JENISHAY FARMS Preliminary Plan El Paso County, Colorado

EL PASO COUNTY
PRE-DEVELOPMENT
COVER SHEET

EL PASO COUNTY
PRE-DEVELOPMENT
PRELIMINARY PLAN
NOTES

EL PASO COUNTY
PRE-DEVELOPMENT
PRELIMINARY PLAN
PLAN SHEET

**GENERAL LOT DRAINAGE NOTES**

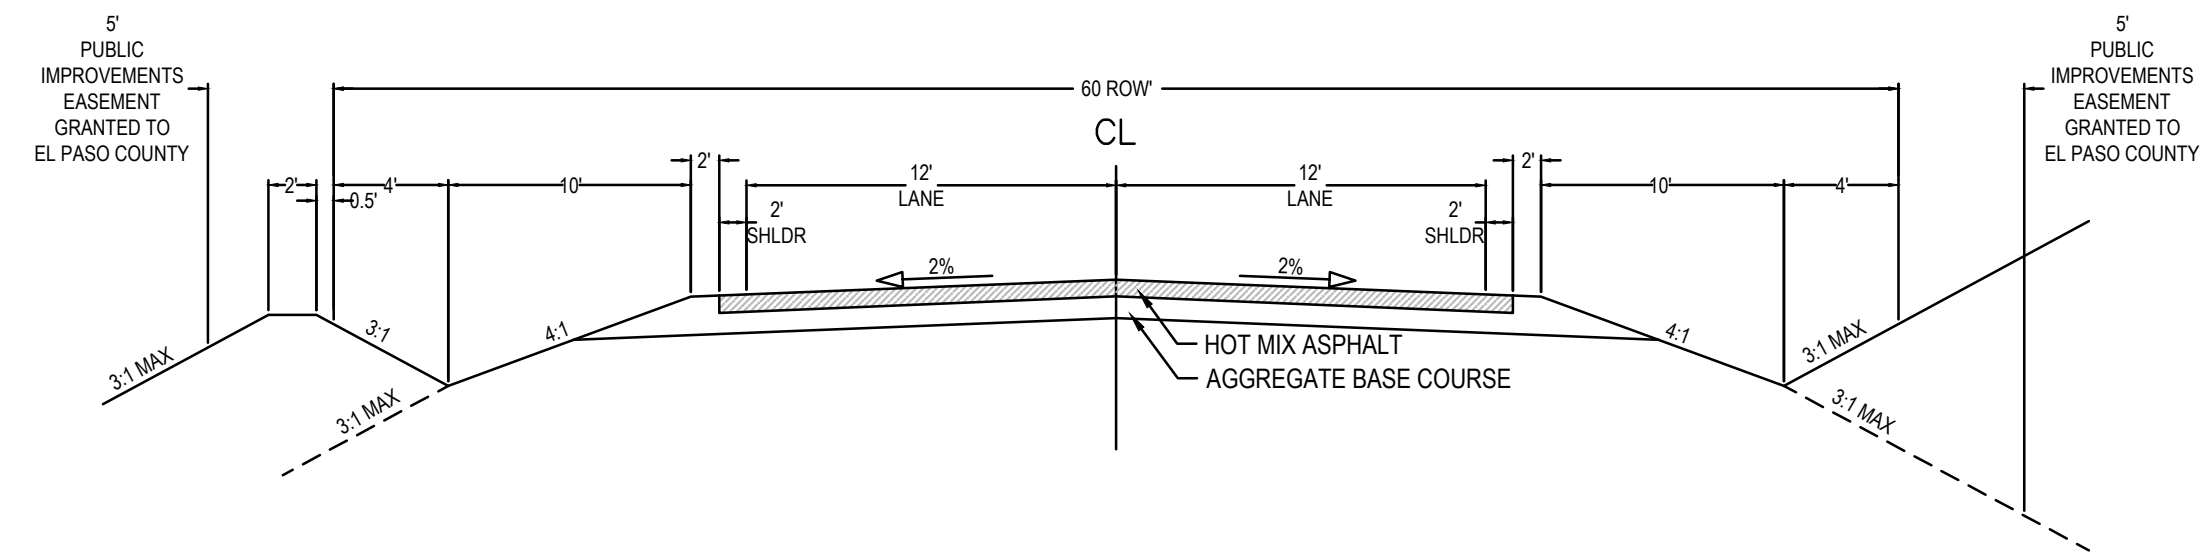
Please note that construction notes are not typically included on the preliminary plan. Staff recommends removing notes 7, 8, 9, 10, 11.

Add the following general notes:

- Floodplain statement
- The following lots have been found to be impacted by geologic hazards. Mitigation measures and a map of the hazard area can be found in the report Geology and Soil Study with Wastewater Study by RMG Rocky Mountain Group dated September 18, 2020 in file SP-20-009 available at the El Paso County Planning and Community Development Department:

- Access to lots 4, 5, and 6 will be limited to the shared/common driveway access. easement A maintenance agreement will be recorded with the final plat.

Preliminary Plat JENISHAY FARMS

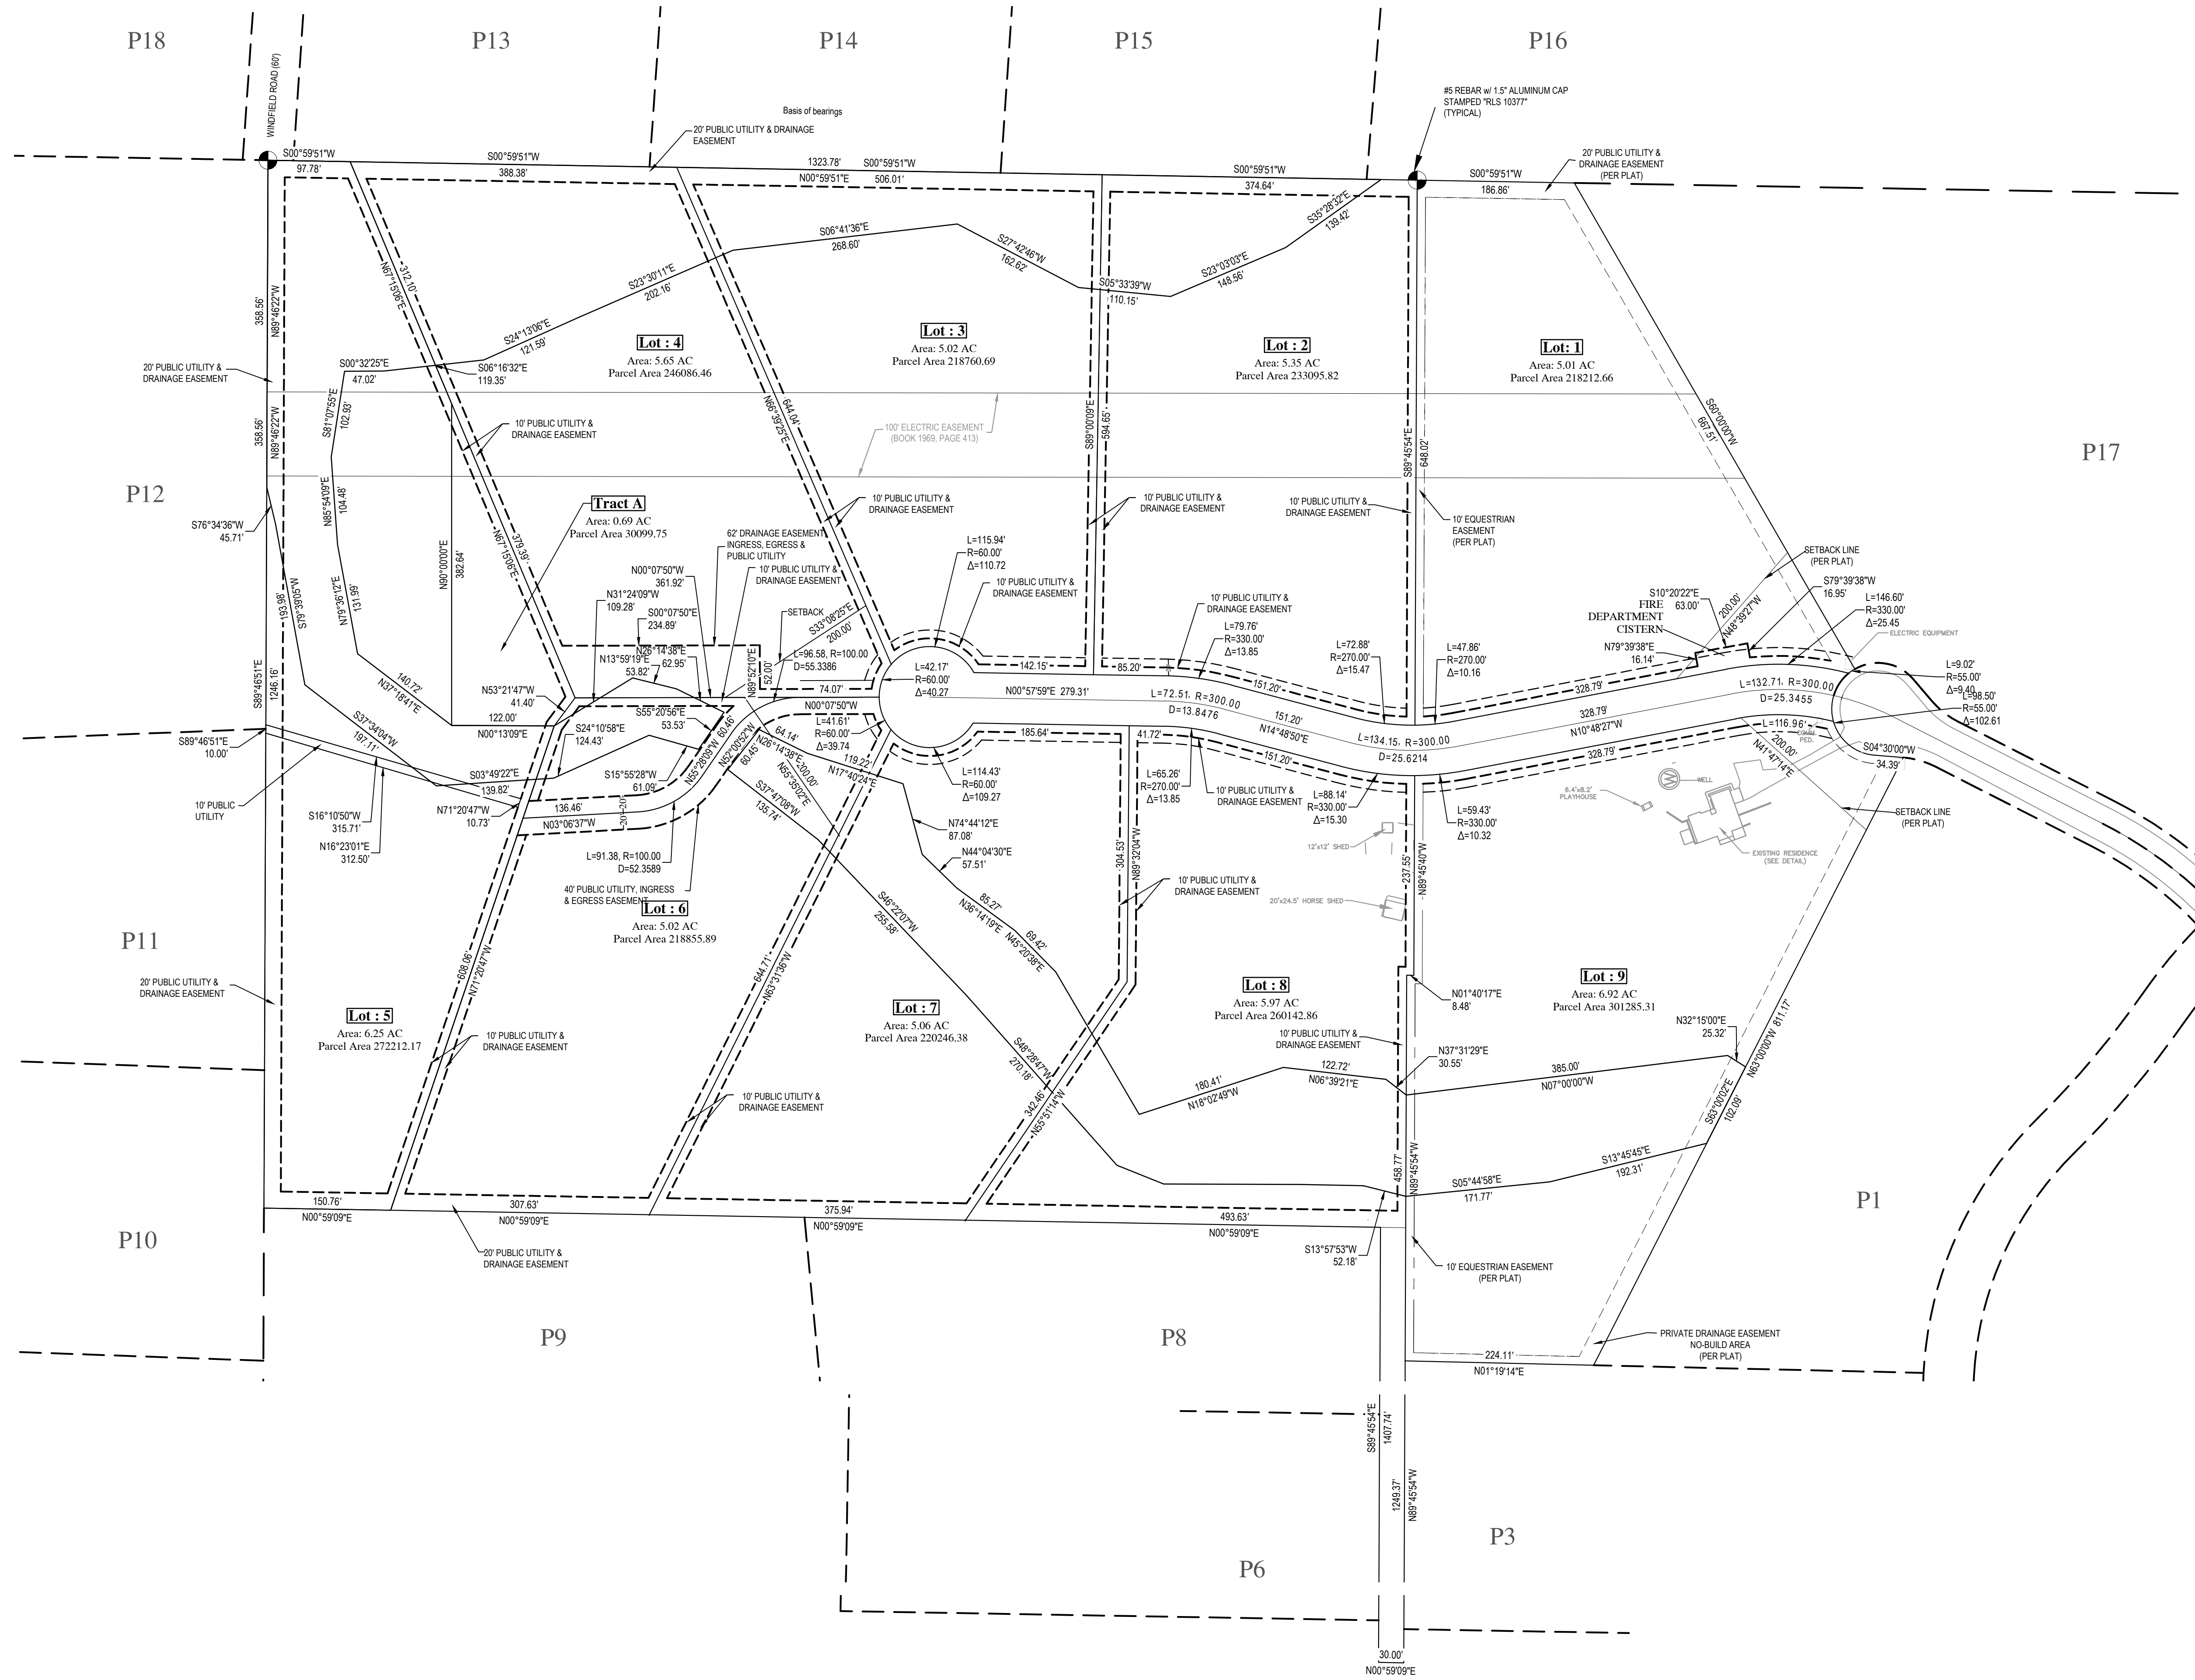
Label. Staff is assuming this is a drainage easement.
Place restriction on this drainage easement for no-build and no-storage of materials.

Identify any no-build easements

Show areas of geologic hazards dedicated as no-build on plat, per soils and geo report

Add the recordation number for all existing easements. Recommend changing to a different linetype from the property line

Update lineweight for the property line so its thicker while the easements are thinner.

Add lot number and lot size in acres.

Needs to specifically state "no-build area"

Why is this a utility ROW versus a utility easement?

replace label with "Shared/Common Access Easement" identify the width of the easement.

All drainage ways that are conveying channelized offsite flows greater than 15 cfs in the 100yr event must be placed in a drainage easement. Update the preliminary plans accordingly.
